Your ref: 3/2018/0468 and 0474

Date: 4th July 2018

Planning Applications 3/2018//0468 and 0474: Erection of a single storey extension to the south of an existing modern extension. Reconfiguration of existing patio and railings. Removal of pointed arch doorway to the southern wall of the modern extension and replacement with a window. Repainting of existing rendered gable to the Hall. Great Mitton Hall, Mitton Road, Mitton BB7 9PQ

Proposed Southern Elevation Scale 1:100

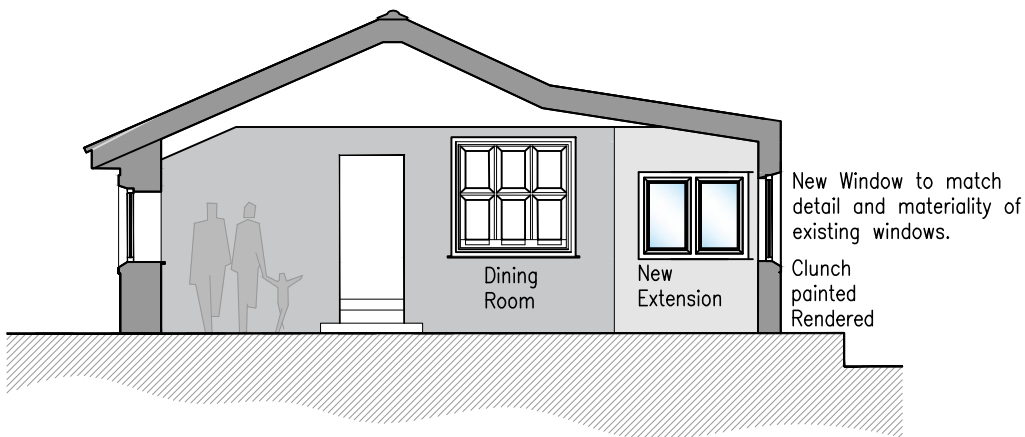
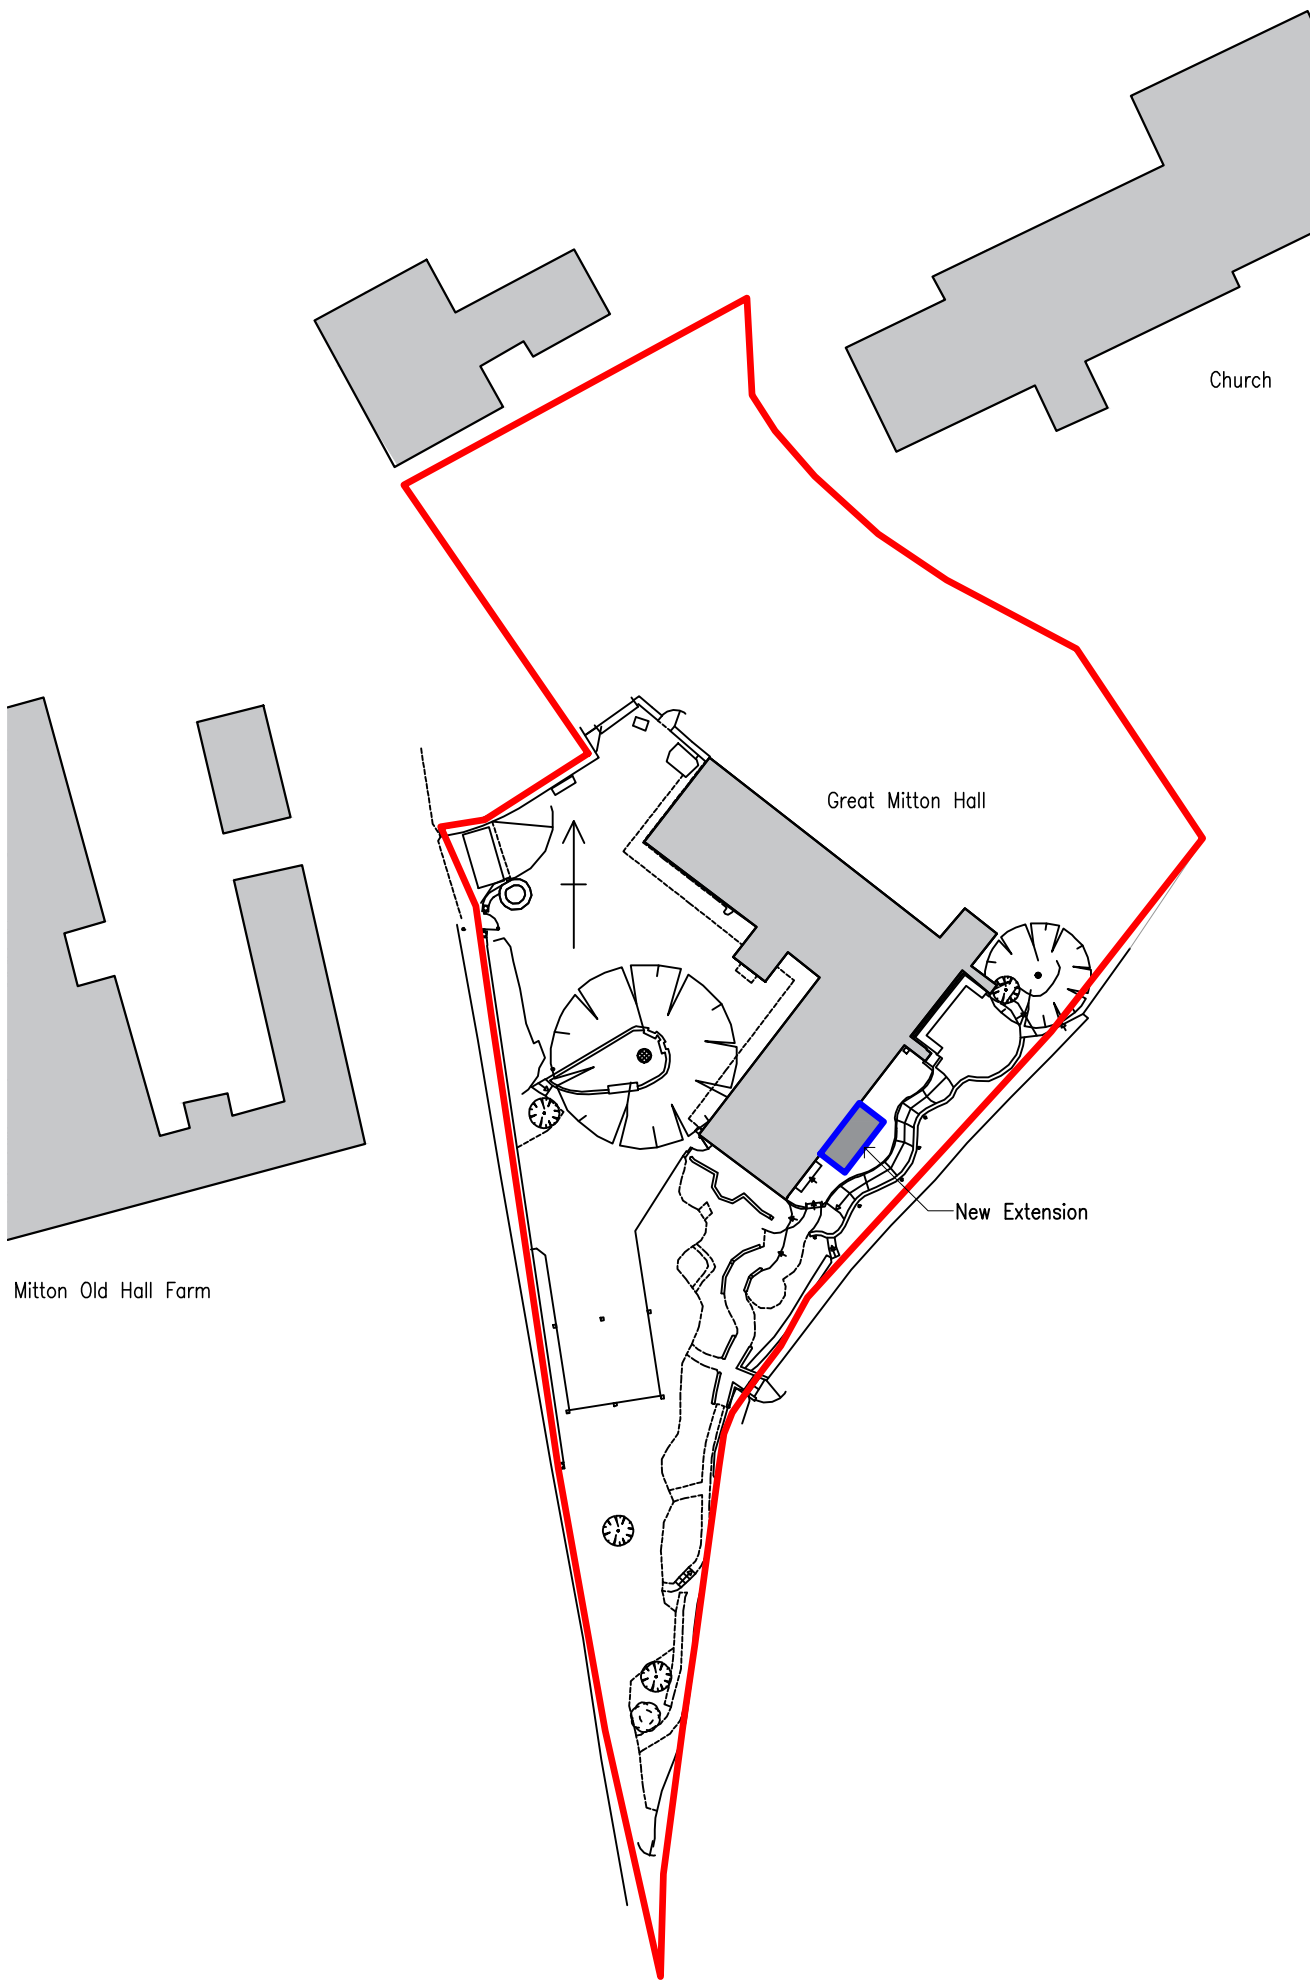
As noted in the heritage and Planning Statements the proposed extension and the replacement of the door with a window only impact an extension to the historic building. The doorway itself appears to be an insertion permitted in 2009 although the detail seems to differ from the plans submitted at that time. As such there is no direct impact on the historic building fabric from these two elements. There is potentially a small impact on buried remains relating to the historic hall within the existing viewing terrace, but without details of this element of the scheme (as existing or as proposed) it is difficult to be sure of the scale of the impact. It seems probable that this area has already been somewhat disturbed by the construction and reconstruction of the extant extension, and it would seem that any impact would be minor and could be mitigated with an archaeological watching brief if required.

of the proposed changes to the door and the new extension would not appear large to us, but we would defer to the expertise of your conservation officer in this regard. We would comment that the major change to the appearance of the building is likely to be the change in paint colour of the gable end and extension wall that is proposed. No detail of the actual colour seem to have been submitted and it must be commented that render on historic buildings in the county is almost always either unpainted or painted white (sometimes with black detailing) and that an alternative colour is likely to appear surprising. The justification for this change is given in the Heritage Statement as:
